Application for a Non-Material Amendment Following a Grant of Planning Permission

DRAWING TITLE HOUSE TYPE A: PLANS & ELEVATIONS
DRAWING NO. HTA-PD-100
REVISION P4

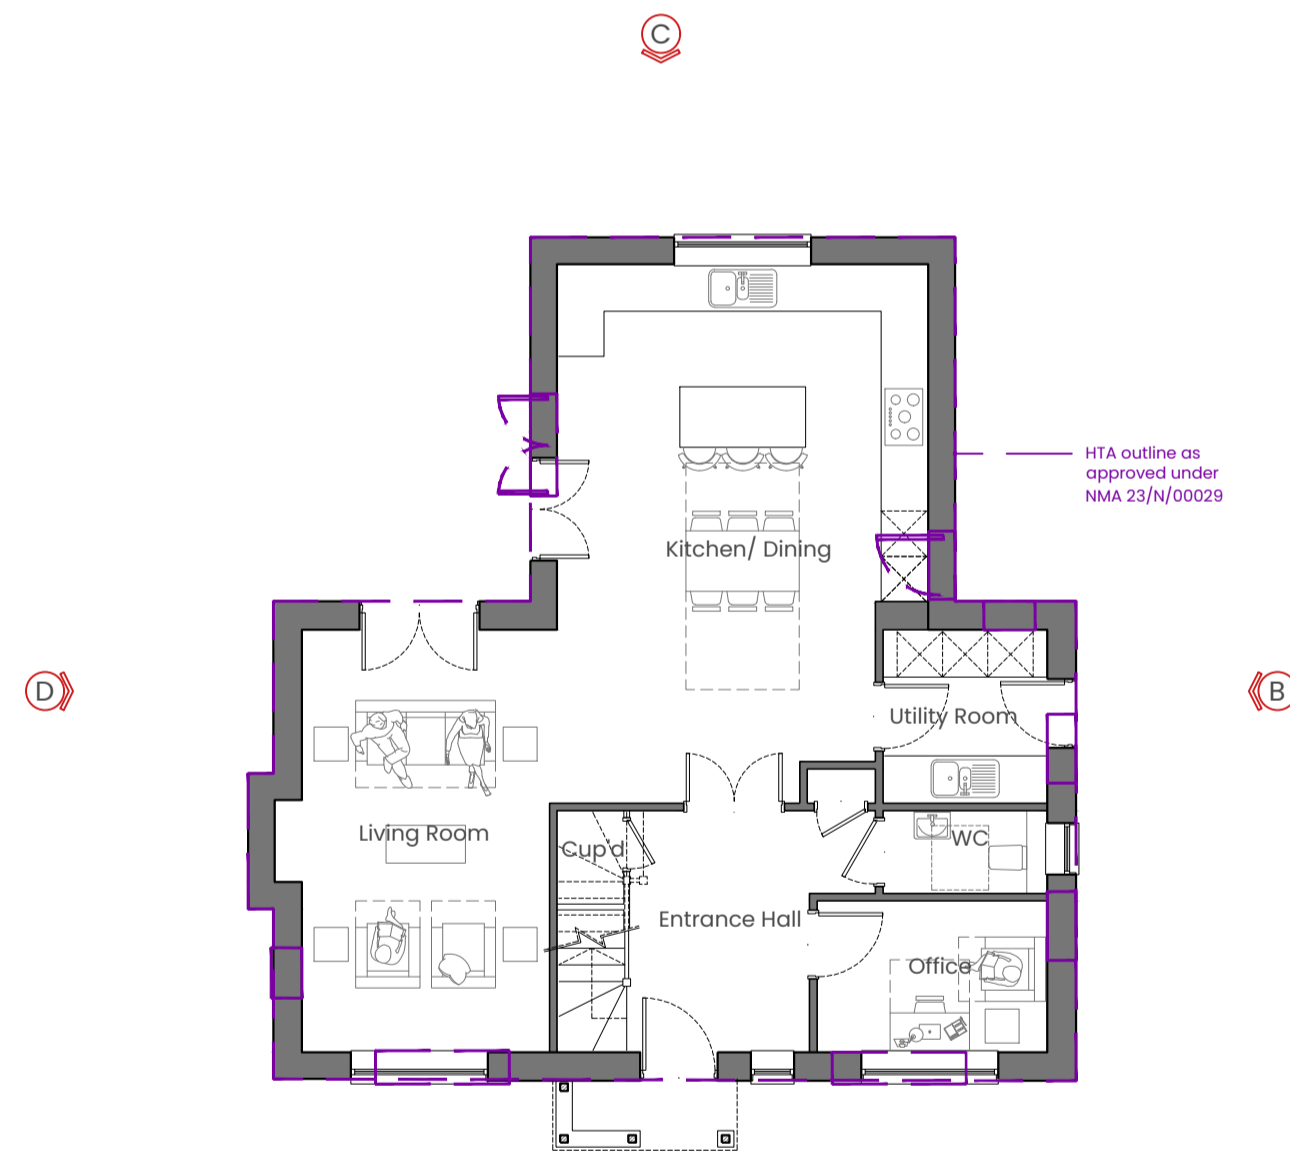
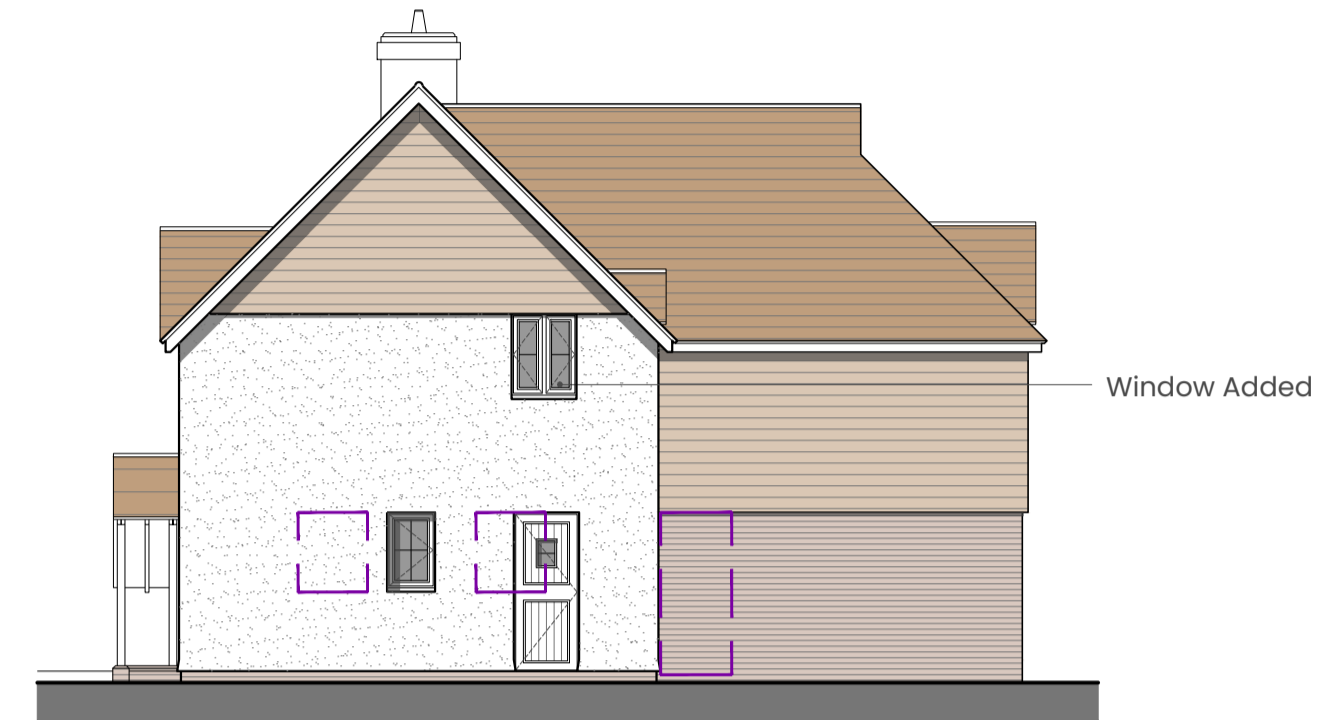
Inclusion of additional window in side elevation of housetype A. Internal reconfiguration works to HTA and HTB. Amendments approved within application 23/N/00029 included for completed following discussions with GBC officers.
